REX CHRISTOPHER PLUMMER  
99 LOUEE STREET,  
RYLSTONE, NSW 2849

APPLICATION NAME: BOWDENS SILVER MINE AMENDMENT  
APPLICATION NUMBER: SSD5765  
**WRE DESIGN AND NATIVE LANDFORM**

Figure 1: WRE plan showing 5 m elevation contours. Source – adapted from DSK-1002 (Advisian, 2020, p. 35)

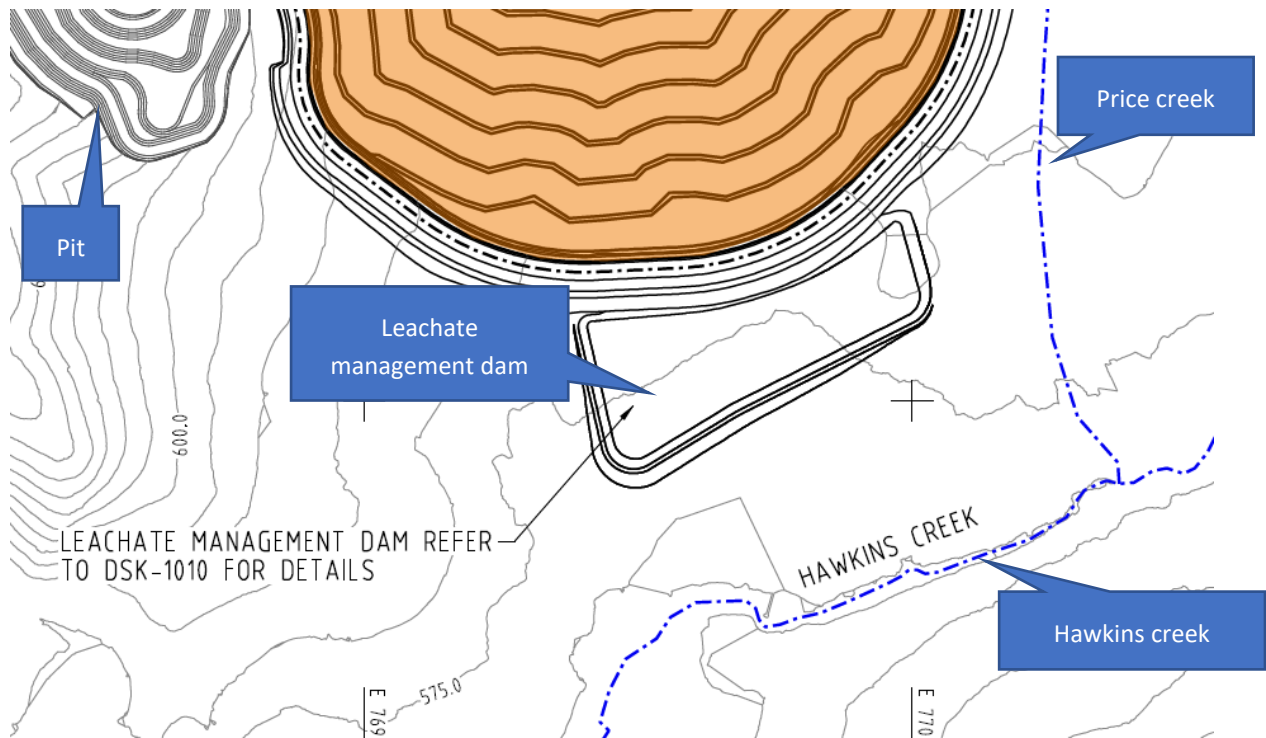
Bowdens response to submissions rebutted criticisms of the WRE design and its lack of sympathy with the immediately adjacent native topography. Attached is a contour map of Bowdens final proposed shape of the WRE; the WRE and the topography to the east are clearly completely contrasting.

Bowdens claim that a design objective for the WRE is to conform with existing natural landforms. If they attempted it then there is no sign of getting anywhere near the objective.

The WRE is a simple crude landform 1800m long (roughly north-south orientation), 500m wide and 100 m high. It has a constant slope of roughly 20 degrees; that's about the same form as a pitched roof on a modern project home. Simply it is a crude pile of rock and dirt which Bowdens have showed no intention to articulate as a long-term (permanent) remnant of mining. Simply it is appalling.

Bowdens have shown some TOKEN WIGGLES in the contours to suggest that they are paying design homage to the adjacent native landform. The scale is so wrong. It is a shallow and fatuous assertion to pursue, and the claim cannot defend the WRE design.

The adjacent (eastern) topography shows a variety of character nothing like the WRE. It has developed a natural drainage pattern in response to the substrates and the local rainfall and (therefore) runoff needs.

On that eastern side of the Bowdens border natural drains run down the slopes to Price Creek. They have formed approximately every 300metres. Bowdens have provided no drainage for surface water; for a planar steeply sloping catchment of 45 hectares this is irresponsible 'design'. What will happen to the rain? Erosion and gullyng will result in silting of Price and Hawkins Creeks.

Visual impact is the main component in the WRE's offense. And Bowdens know that. If sections were presented showing line of sight from Lue and Battens roads it would be clear. It will intrude visually and it is ugly and out of character.
